Planning Inspectorate

Re: Botley West Solar Farm - Examining Authority Second Written Questions (ExQ2)

Forestry Commission Interested Party/Unique Reference Number: BWSF-ISP001

Title  
 Landscape, Ecology and Amenities Plan

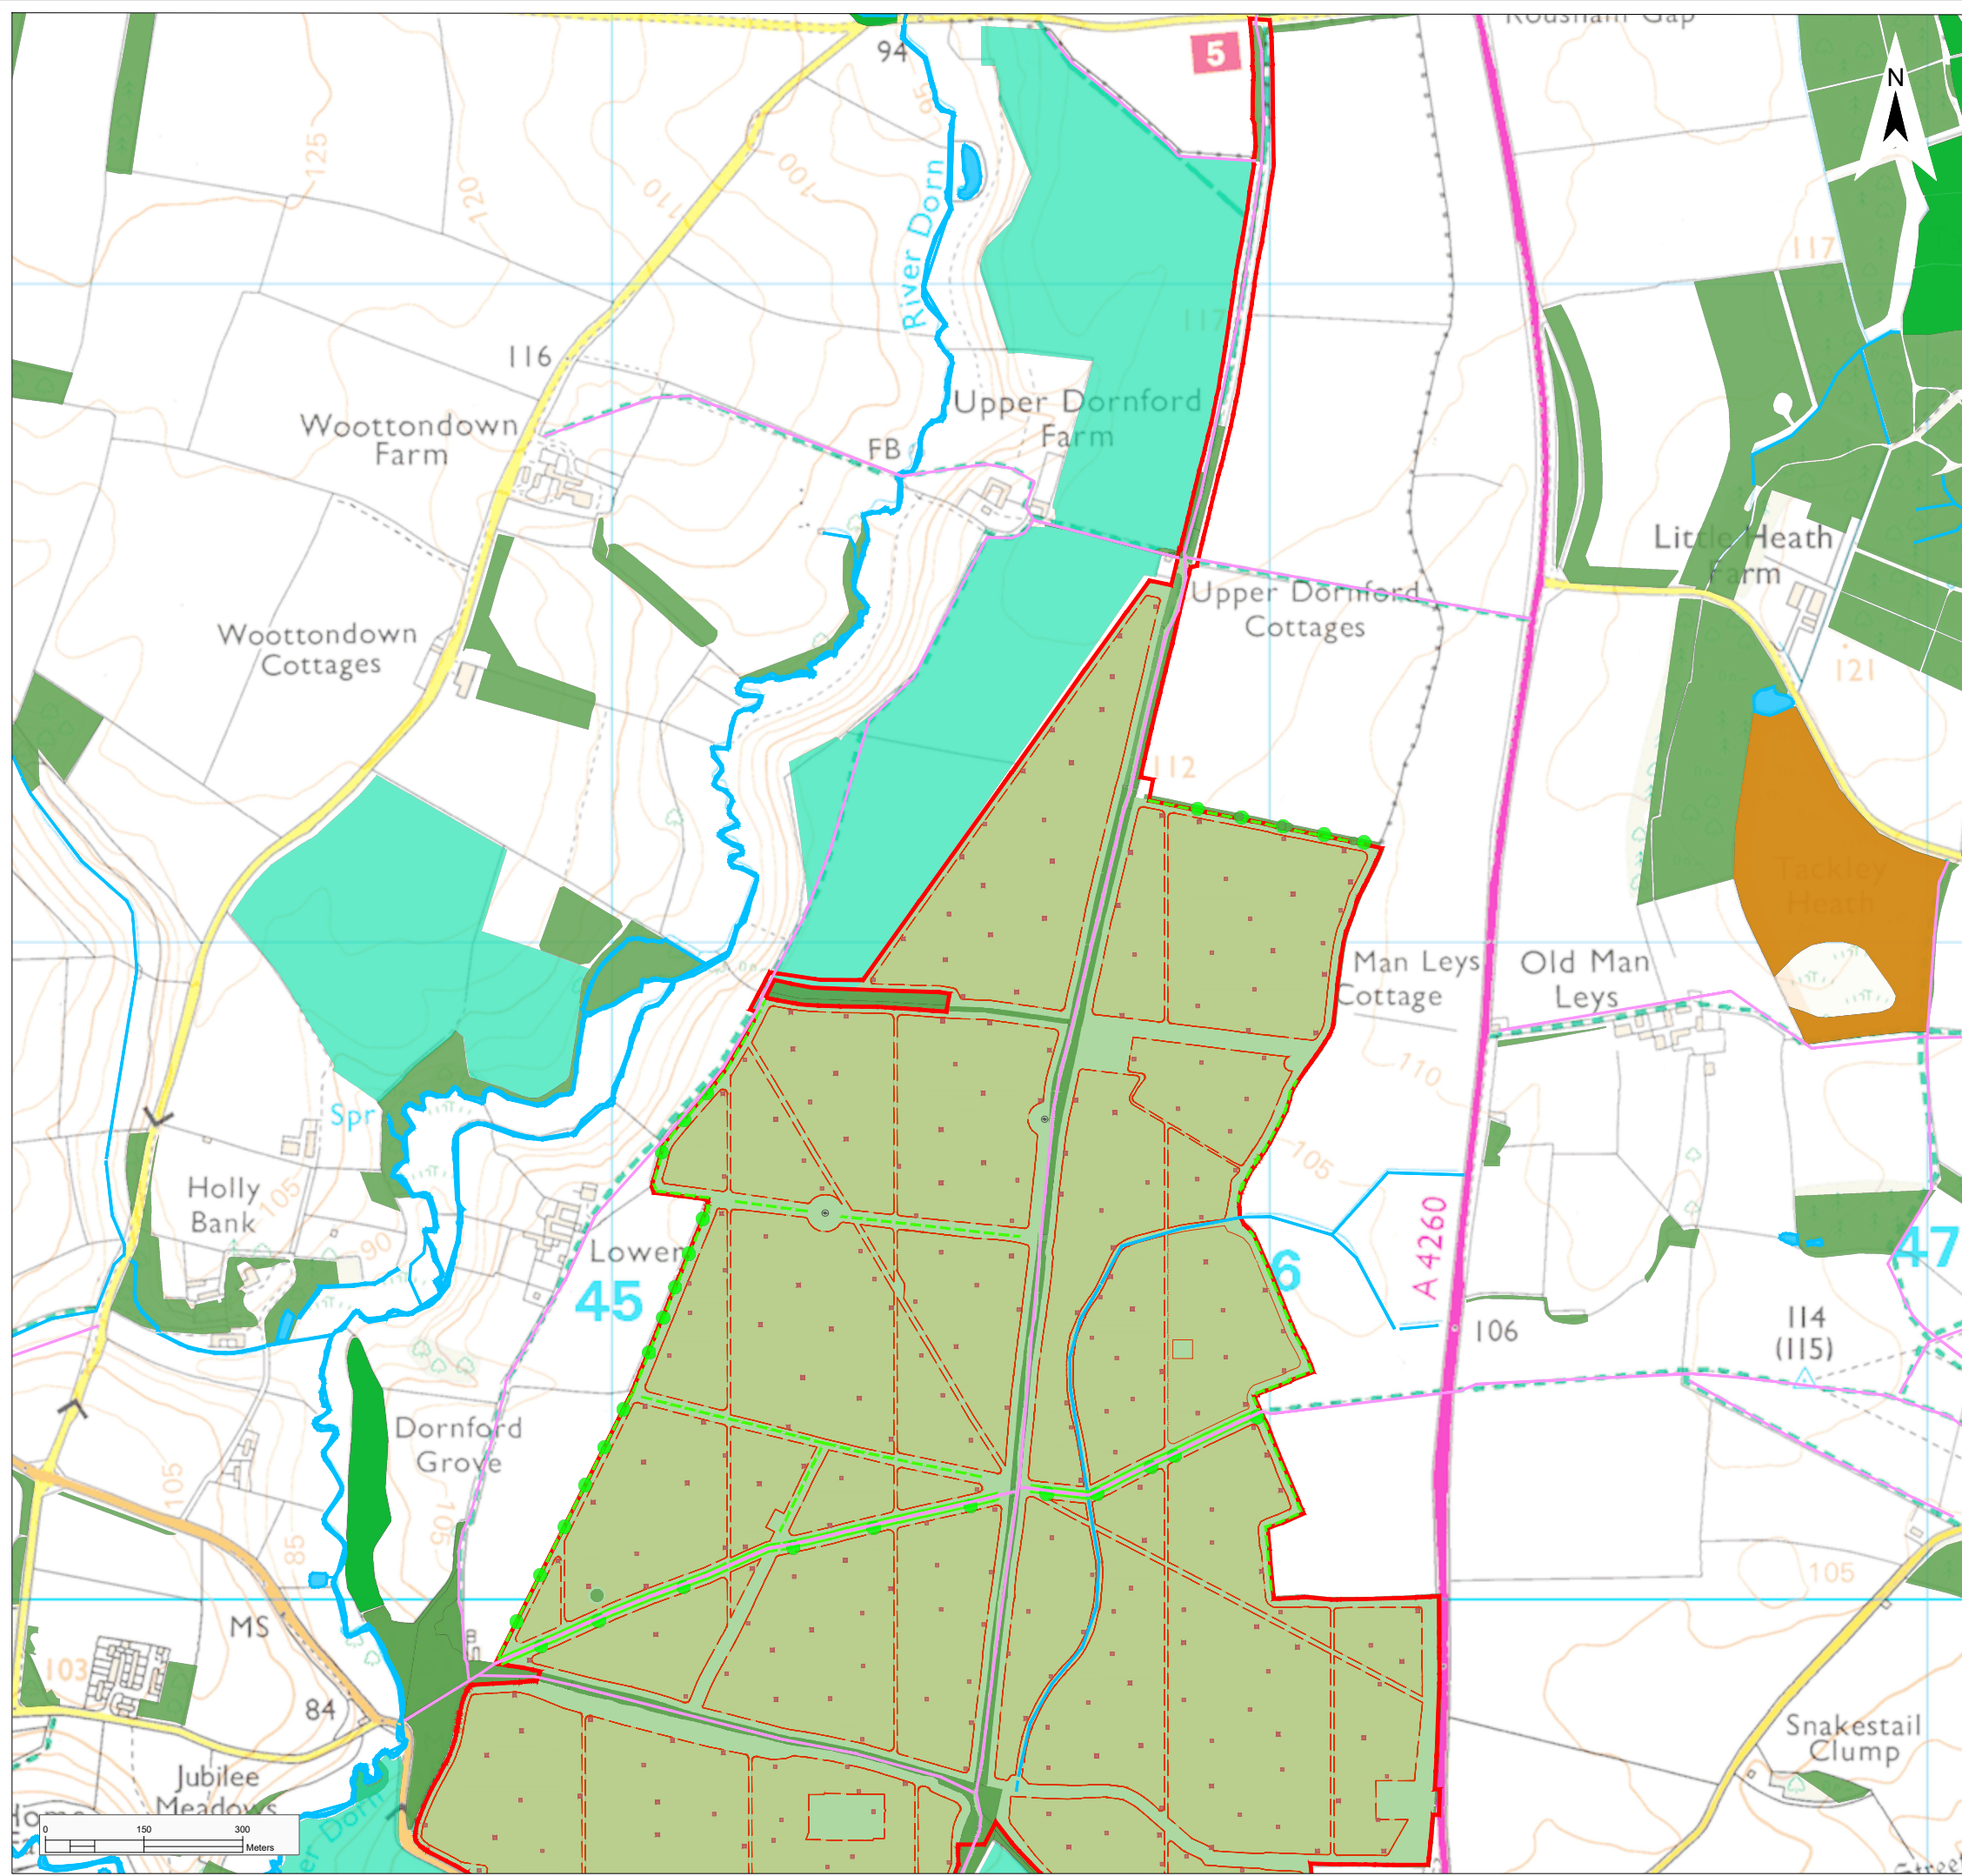
The Applicant’s Environmental Statement suggests that adopting a 15m buffer will avoid impacts to Ancient Woodland. As outlined in our ‘Woodland buffering’ section of our consultation response, a 15m buffer is a **minimum** starting point designed for tree root impacts. There are other impacts that need to be considered before direct and indirect effects of irreplaceable habitat, and deterioration of condition can be considered avoided. Measures need to be effective for the specific site and proportionate to the project’s landscape scale and the cumulative effects on multiple blocks of ancient woodland, connectivity and functionally linked habitat.

If the current proposals were approved, it is our view that deterioration to ancient woodland is likely to occur. The changes and measures identified in our consultation REP2-054 would help the applicant to avoid deterioration. This includes bigger and better-quality buffers, better woodland edge design and enhancement and more significant levels of woodland enhancement and creation.

This is referred to in Item 2 of our previous response (REP2-054). The proposed woodland created for this project (less than 5 Ha) represents a small proportion of the whole site (approximately 0.35%). The areas of woodland creation proposed also appear to be very small and limited to narrow strips spread across the site.

As advised in Item 1 of our response REP2-054, the project needs to explicitly consider **all** direct and indirect effects on ancient woodland have been assessed and mitigated for as set out by the Standing Advice under the ‘**Direct and indirect effects of development**’ section. Following the advice we have given in REP2-054 would help to

REP2-054 provides advice on meeting good practice woodland creation design. A greater extent of woodland creation that is well-designed and managed is encouraged as a more proportionate to the scale of development in the context of national targets, local biodiversity policies and targets (including the local nature recovery strategy) and could help to avoid the impacts to ancient woodland.

Given the reasons above and as outlined in REP2-054, our view is that significantly larger and well designed buffers with an enhanced woodland edge habitat and improved connectivity more broadly (through habitat creation and enhancement) is required to avoid degrading ancient woodland habitat.
